COUNTY COUNCIL'S RESPONSE TO CONSULTATION ON THE FOLLOWING DEVELOPMENT PROPOSAL

Application No: 18/00193/REM-3

Proposal: Reserved matters application to 14/02156/OUT - for appearance, landscaping and layout (including the layout of the internal access roads, footpaths and cycleways) for 37 dwellings.

Location: Land South Of Cotefield Business Park, Oxford Road, Bodicote.

Road 6
Horiz. 1:500 Vert. 1:50

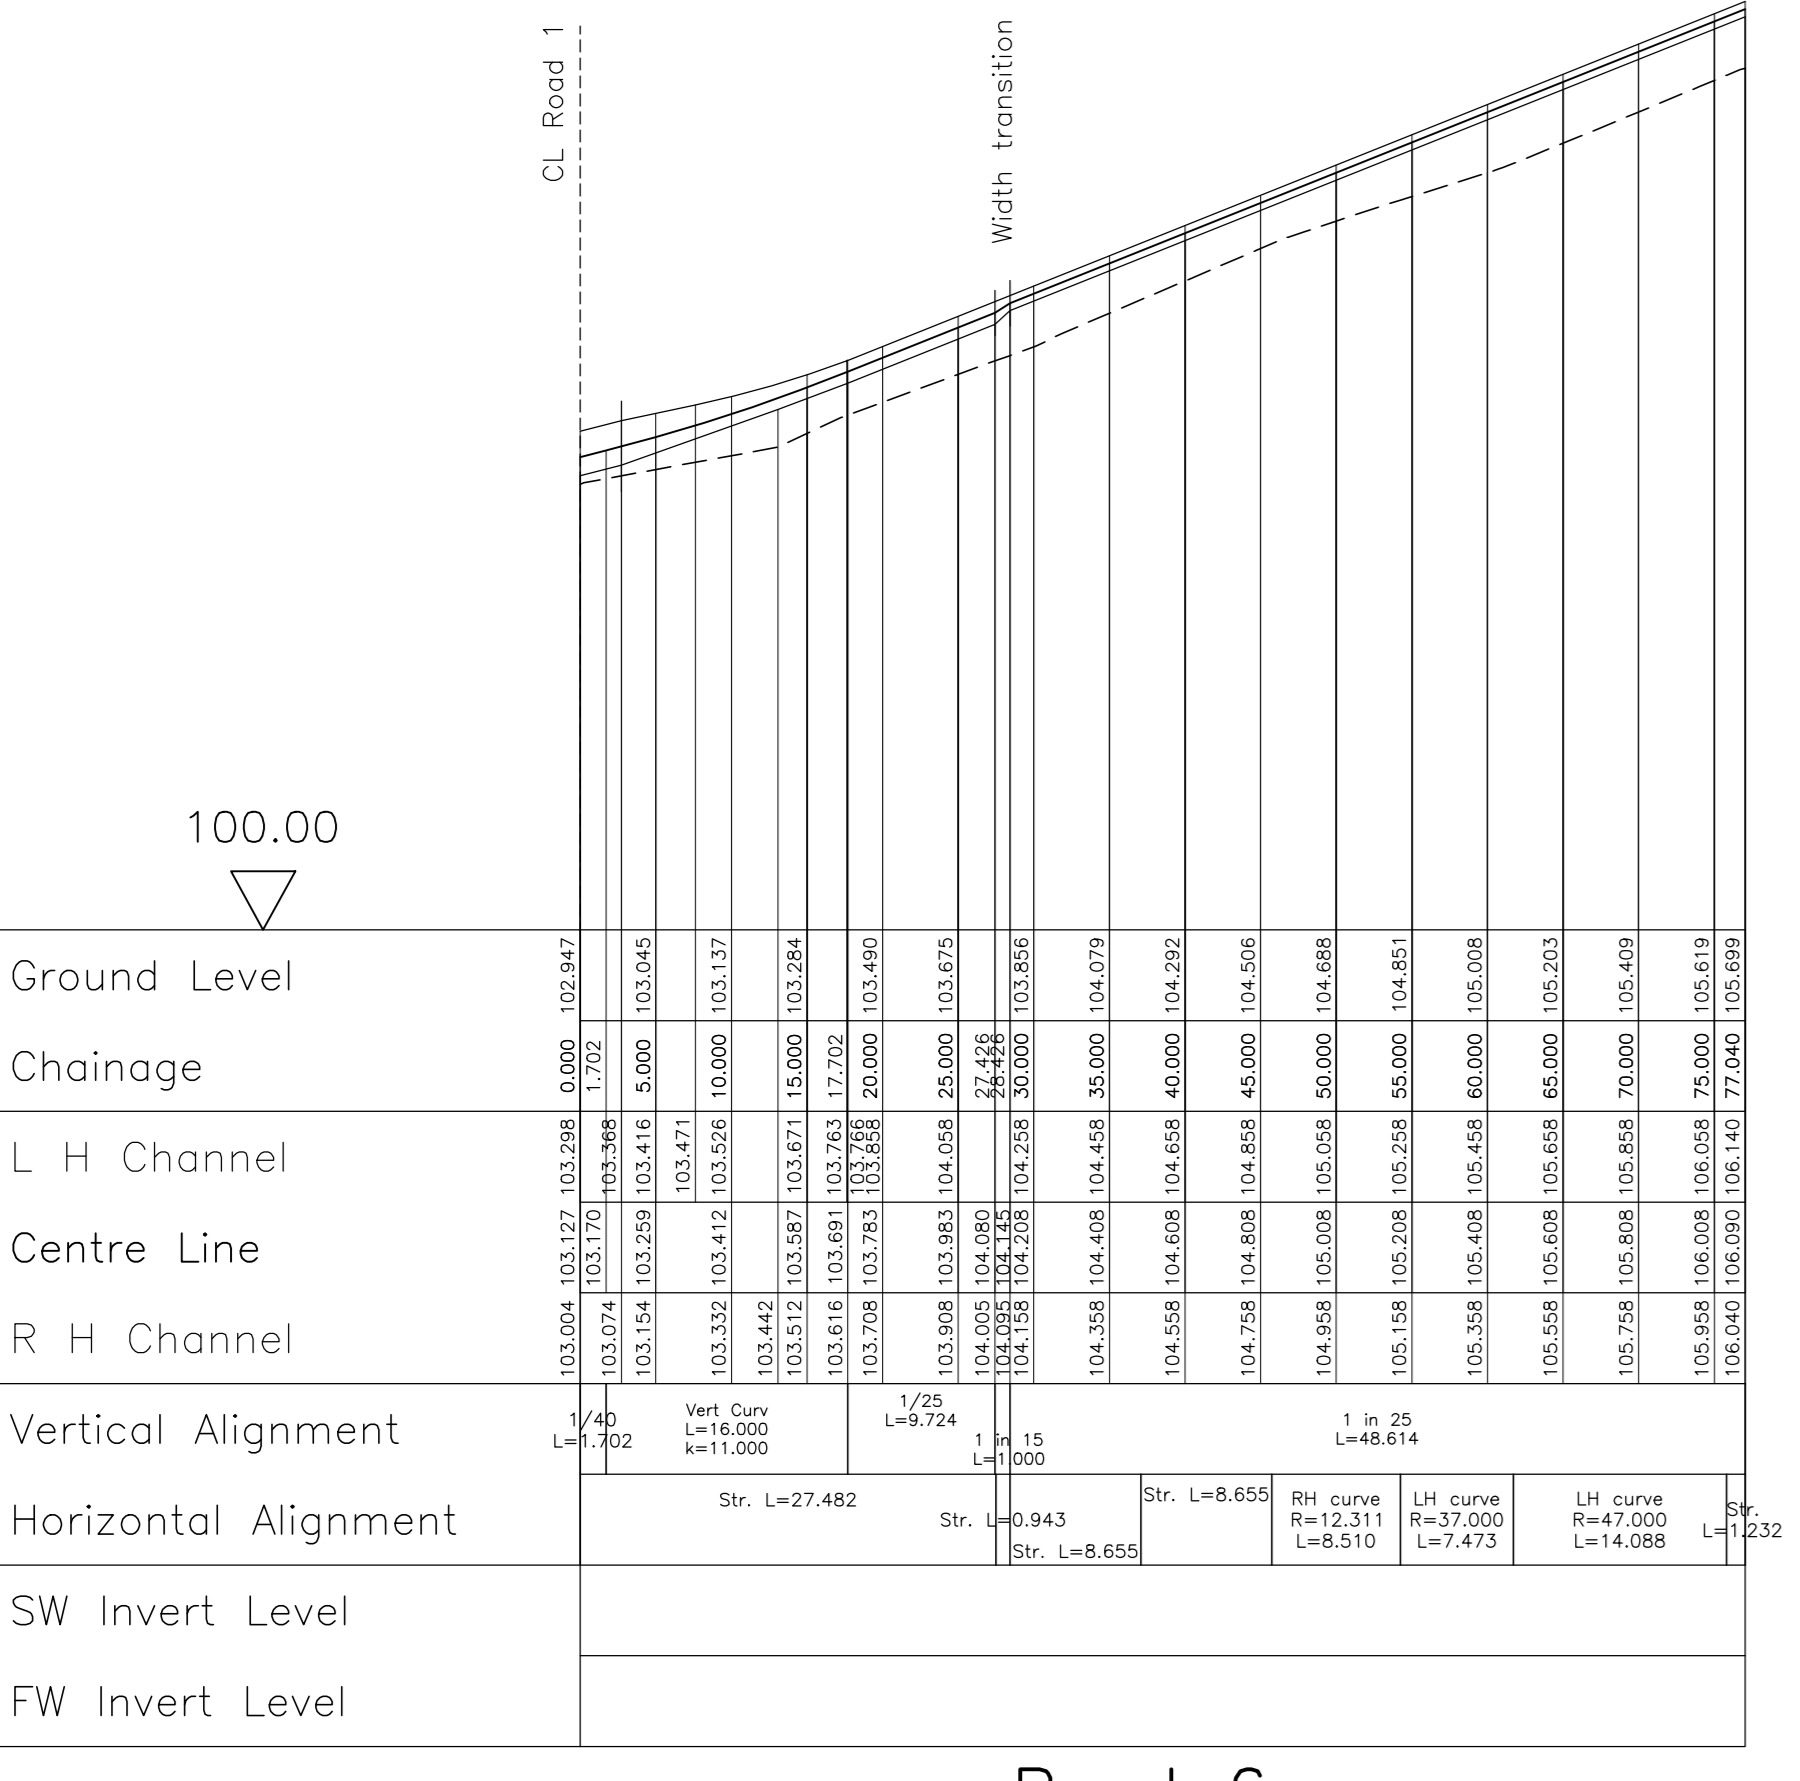
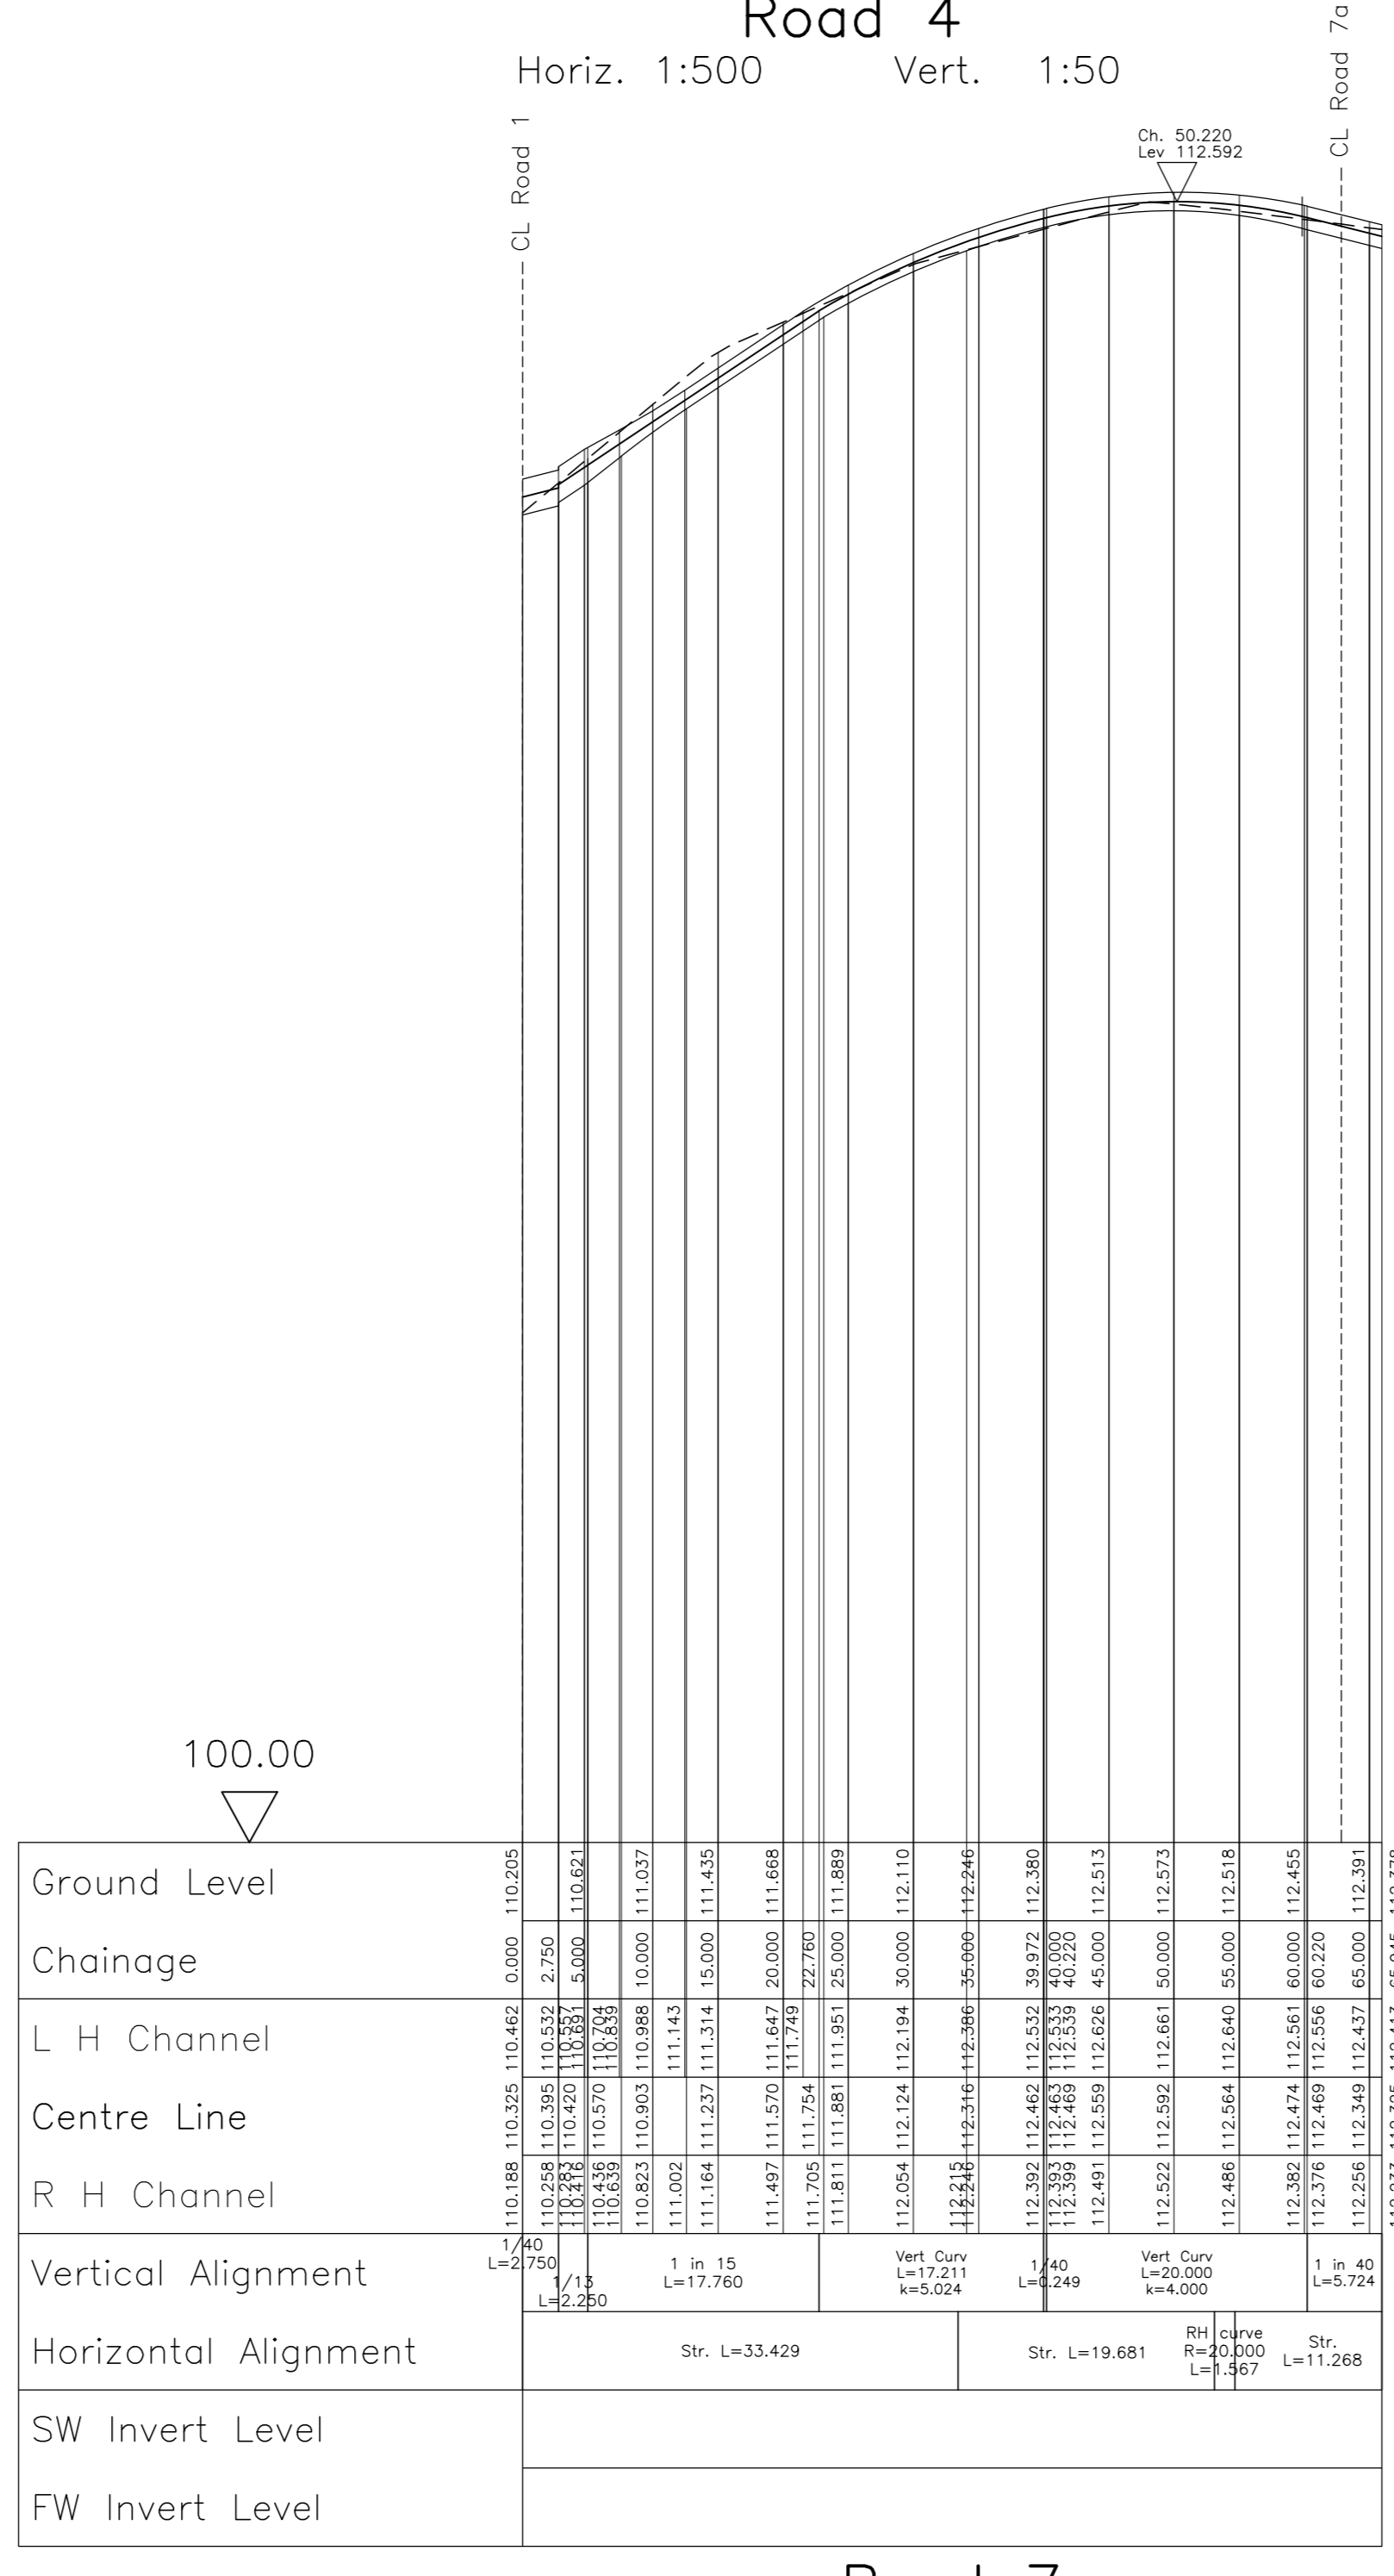
Regarding the proposed levels, 1:12 is the absolute maximum gradient that the Local Highway Authority will accept, and this only over very short lengths of road where it is unavoidable. If the gradient is 1:12 or above over longer stretches of road, this will inhibit access to parts of the development for the elderly, disabled people, and parents with small children or who move pushchairs. Therefore, this is contrary to paragraph 32 of the NPPF and I recommend objection on these grounds.

OXFORD ROAD, BODICOTE - PARKING STRATEGY

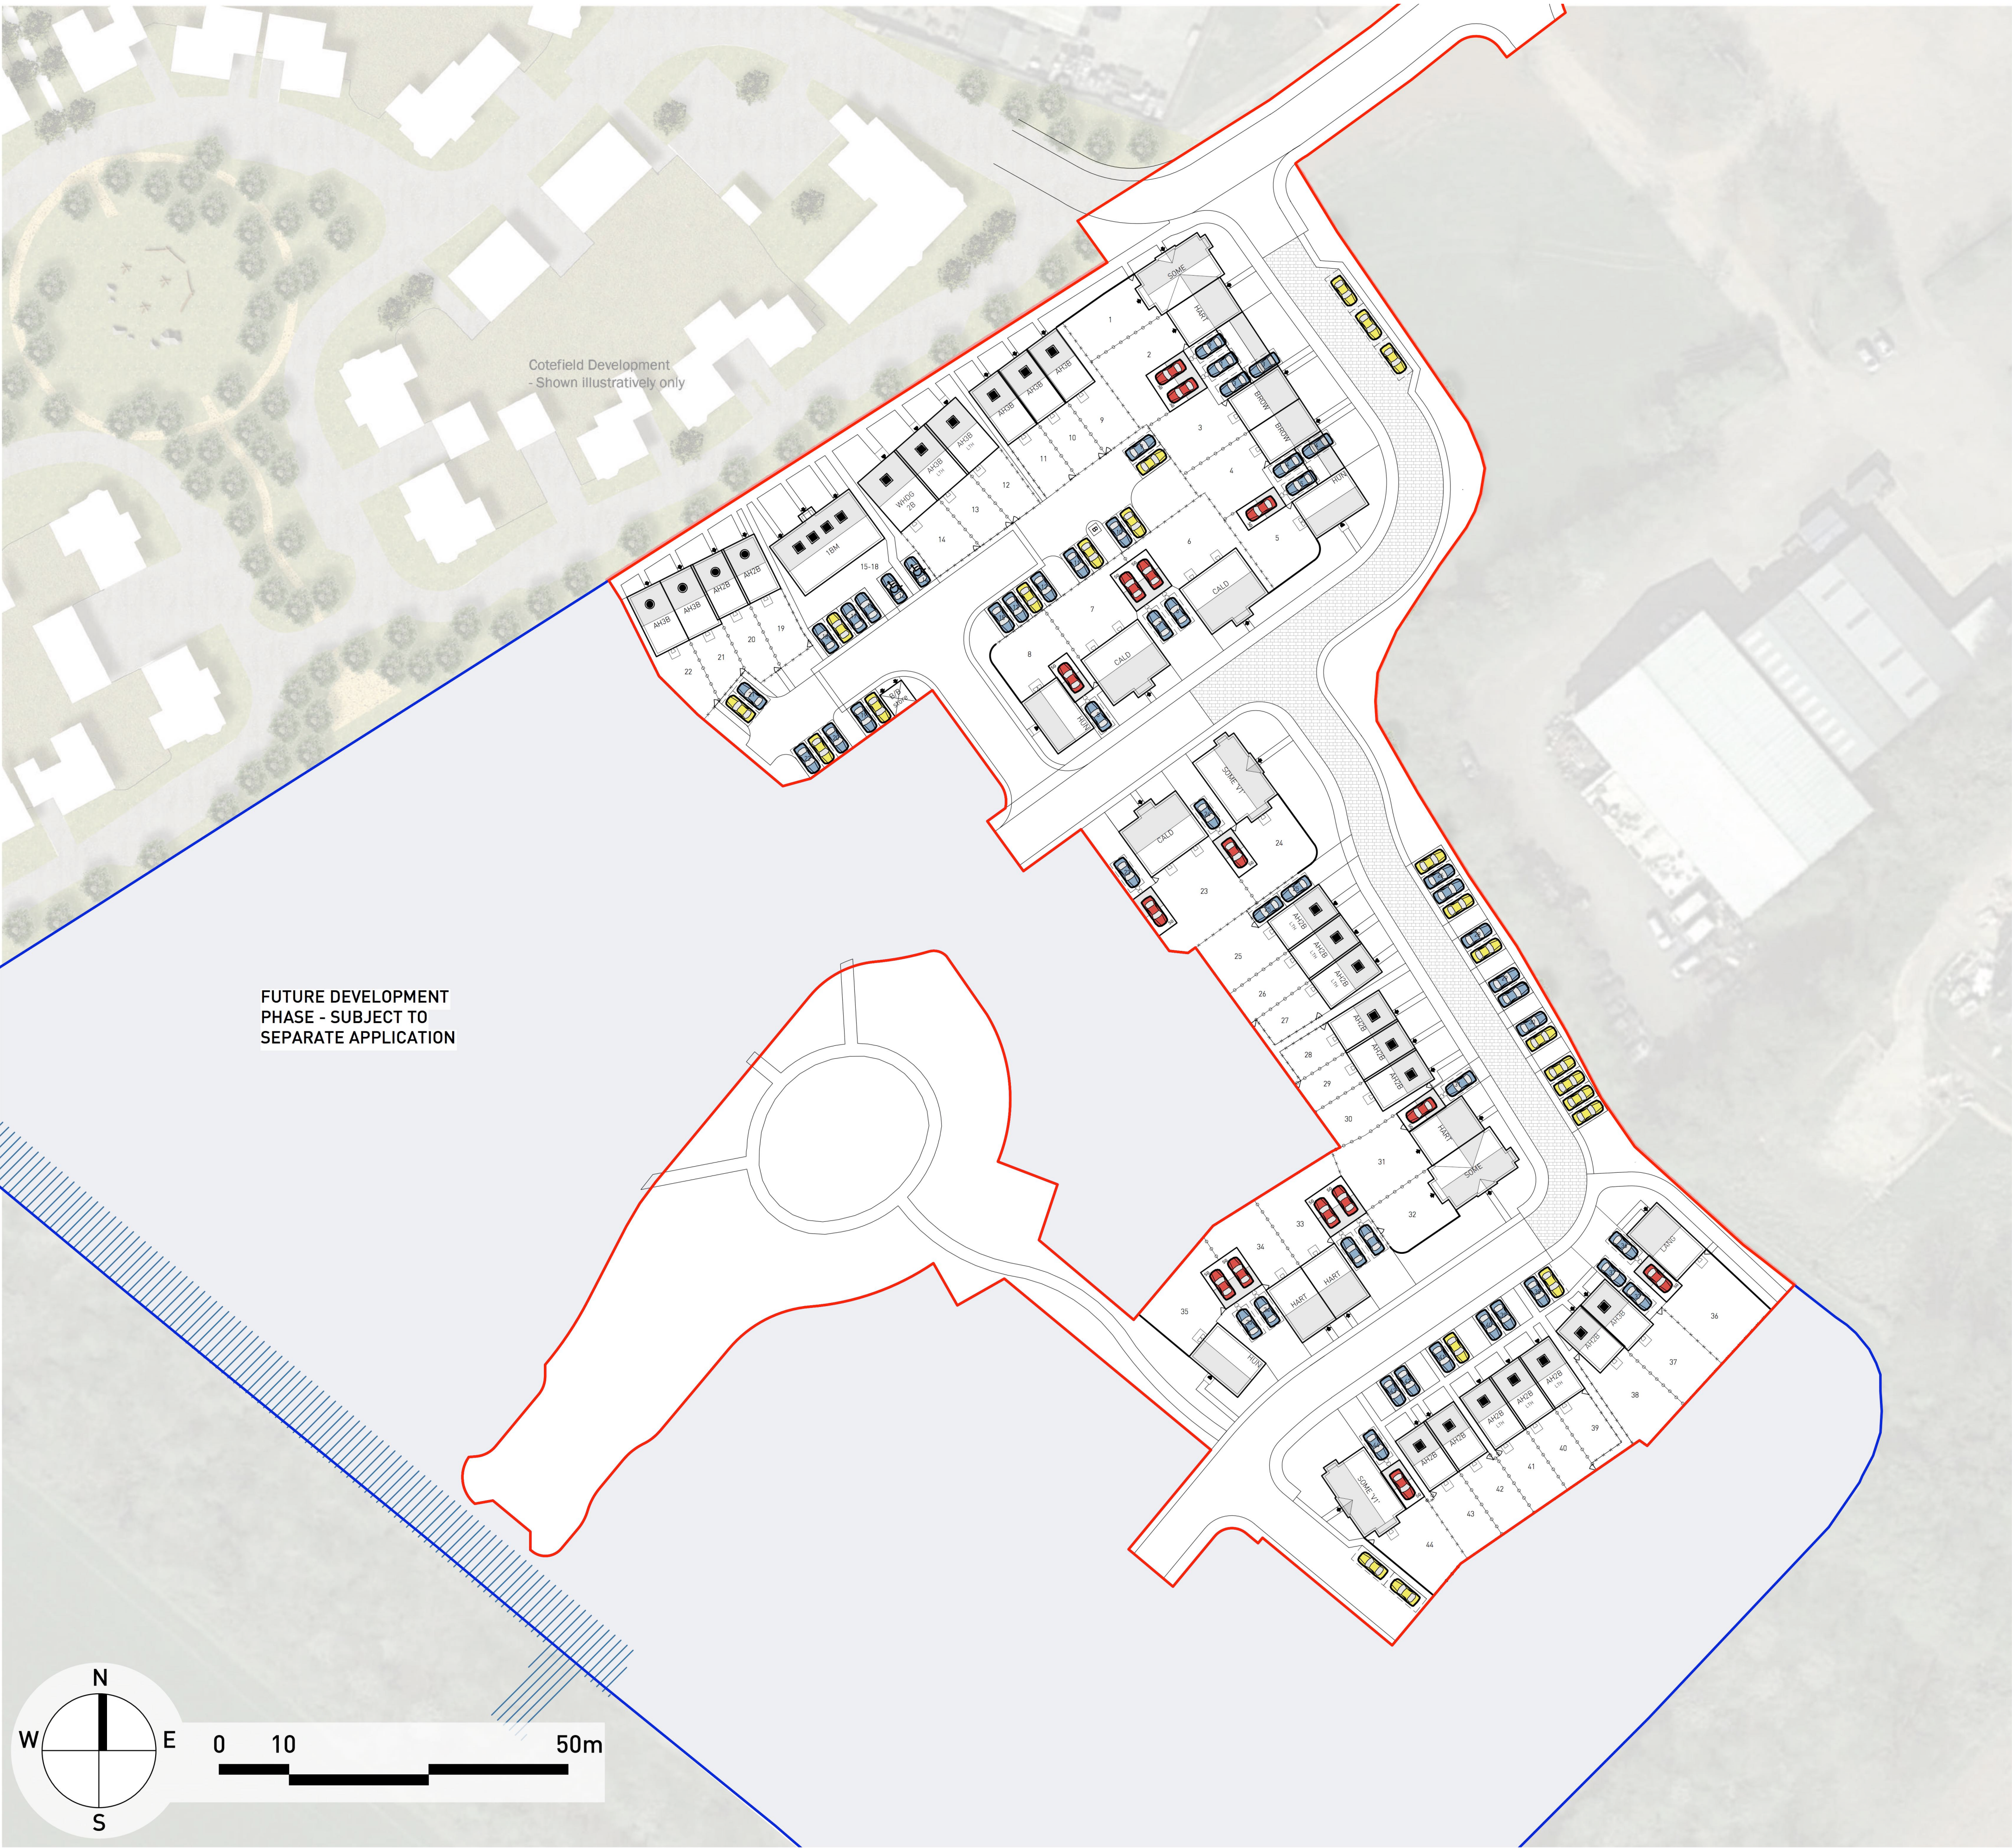
If the spaces within the allocated garages are included, the applicant has provided a total of 77 vehicular parking spaces. Although, this number meets the standards set out in Oxfordshire County Council's Residential Roads Design Guide, the spaces are not correctly distributed. For example, plots with two-bedroomed open market houses appear to have two allocated perpendicular spaces, while plots with two and three bedroomed affordable houses have been allocated one perpendicular space, and might, depending on the number of visitors to the development by car at any one time, be able to use one of the visitor perpendicular spaces. However, these spaces may not be available to visitors if they are being used by residents, and could lead to visitors parking unsafely on access roads. The main access road through the site is 5.5m wide. Therefore, a lot of overspill parking could inhibit access to the development for refuse and emergency service vehicles.
